Approval of details reserved by condition imposed under FG/69/16/OUT
(APP/C3810/W/17/3166634) relating to condition 6-proposed traffic light system.

Paddock House 44 Ferringham Lane Ferromg

Thank you for your internet representation made on 27th April 2018 which has been recorded as **'an objection'** with the comments as follows:

Project: 44 Ferringham Lane
 New Road Design

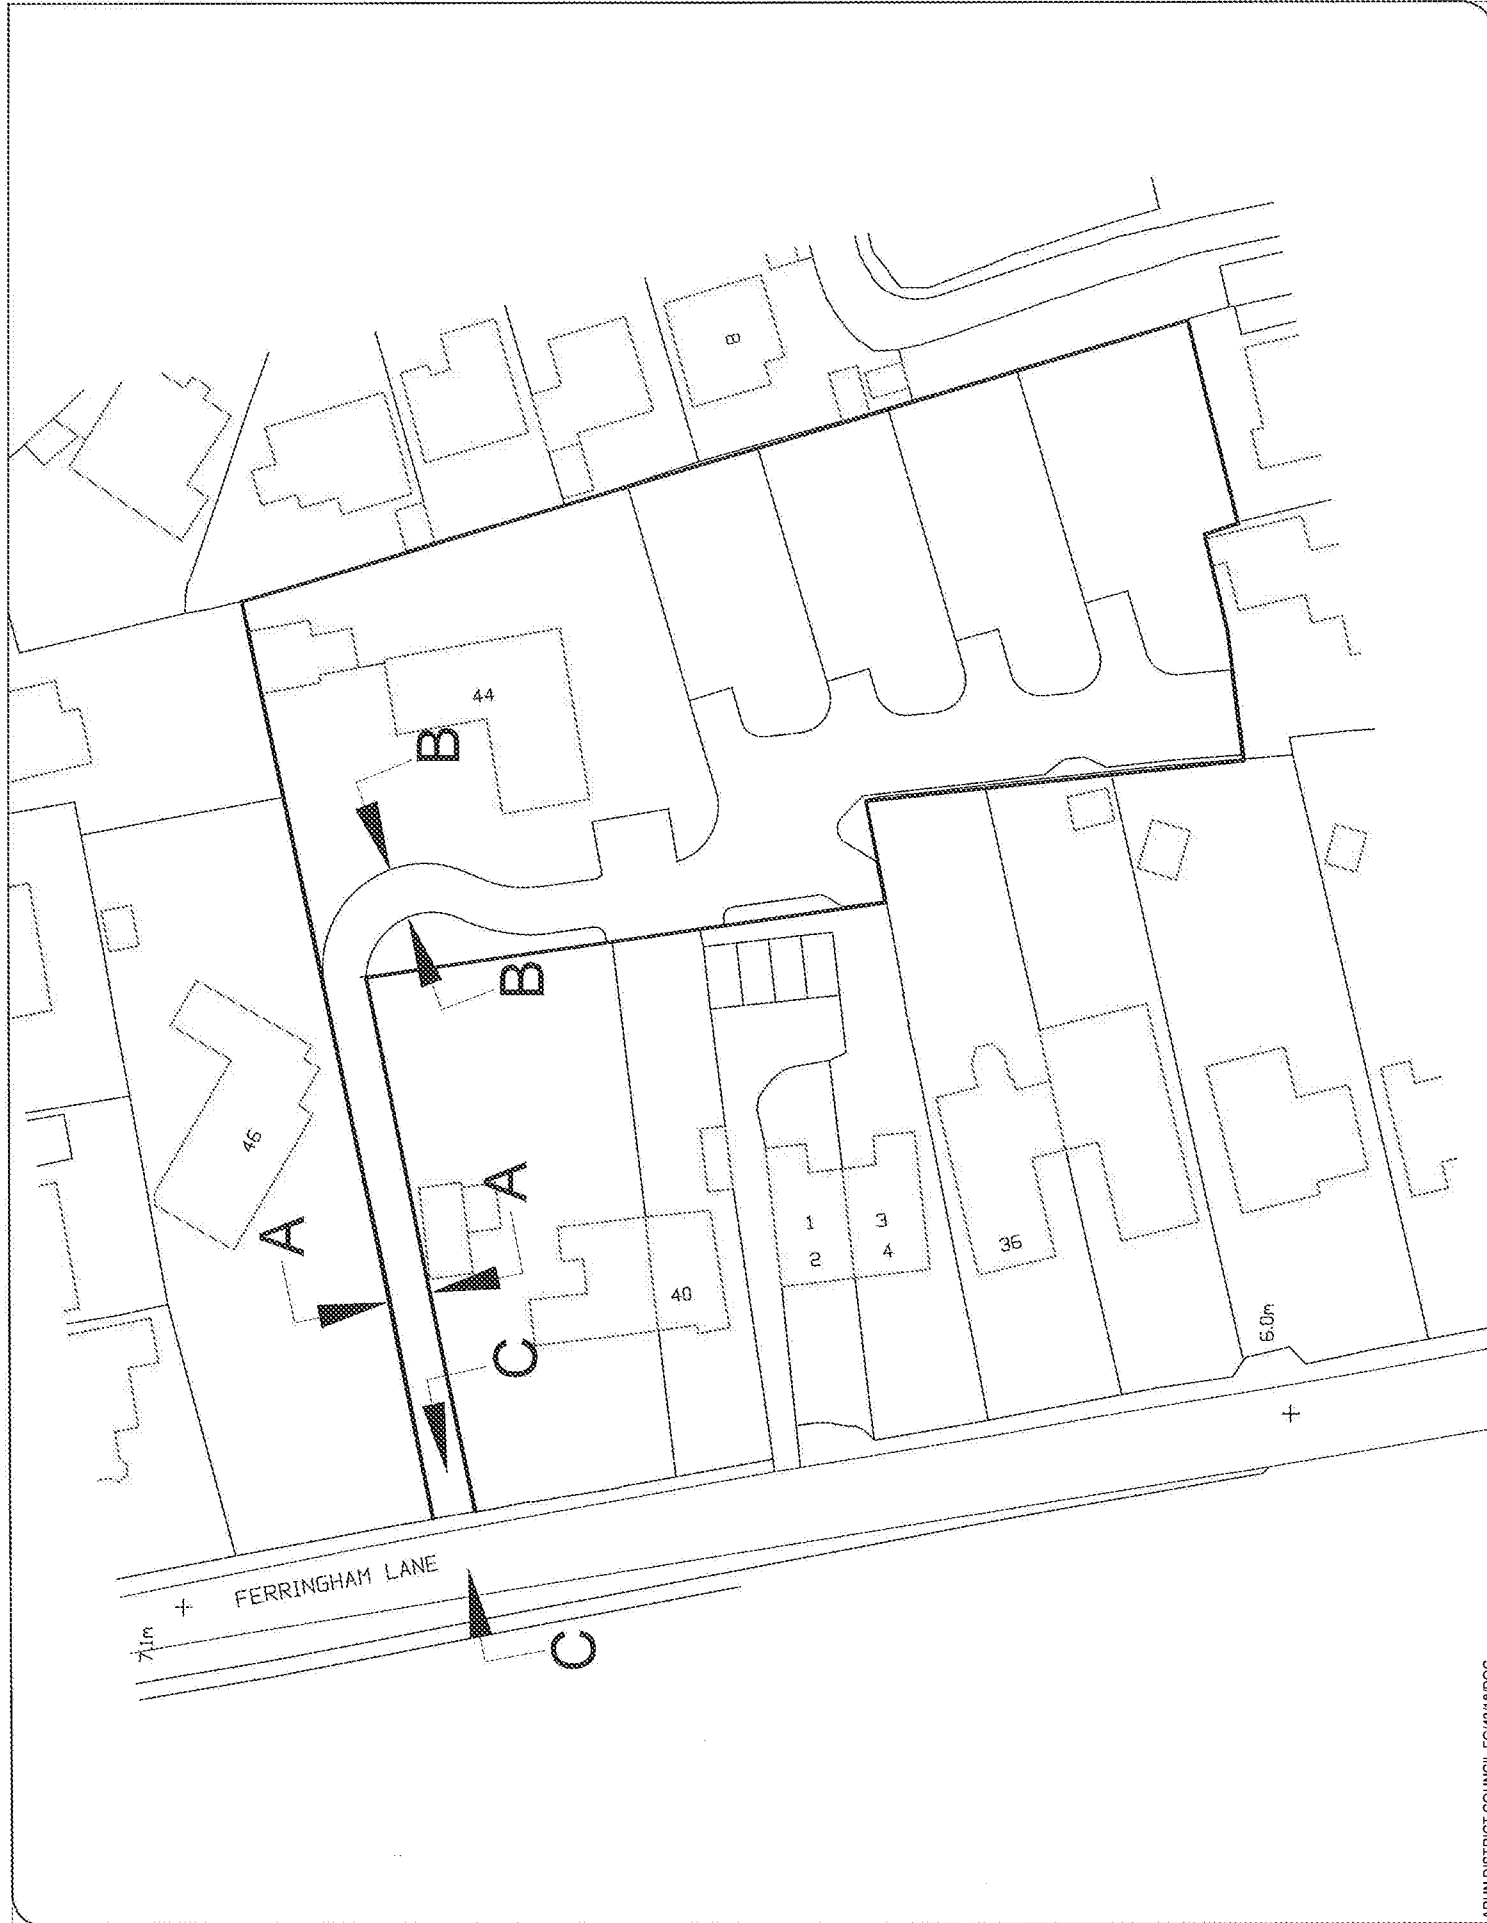
The proposed development at 44 Ferringham Lane has Appeal Conditions that must be met before work commences. Namely the width of access and visibility splay. The developers do not have a 4 metre wide access (as has been historically proven with the old deeds and documents from the original sale of land from 42 Ferringham Lane) and they also have no control over the neighbouring properties sight lines, therefore they lack the visibility splay too (they only have control over their 3.65 metre wide access drive). These important facts seem to have been glossed over, as does how the traffic lights would actually work in practice with cars waiting to enter and exit the site. Surely the conditions have been put in place to protect the safety of all the road users of Ferringham Lane, so allowing work to begin before these were guaranteed puts pedestrians and drivers at risk?
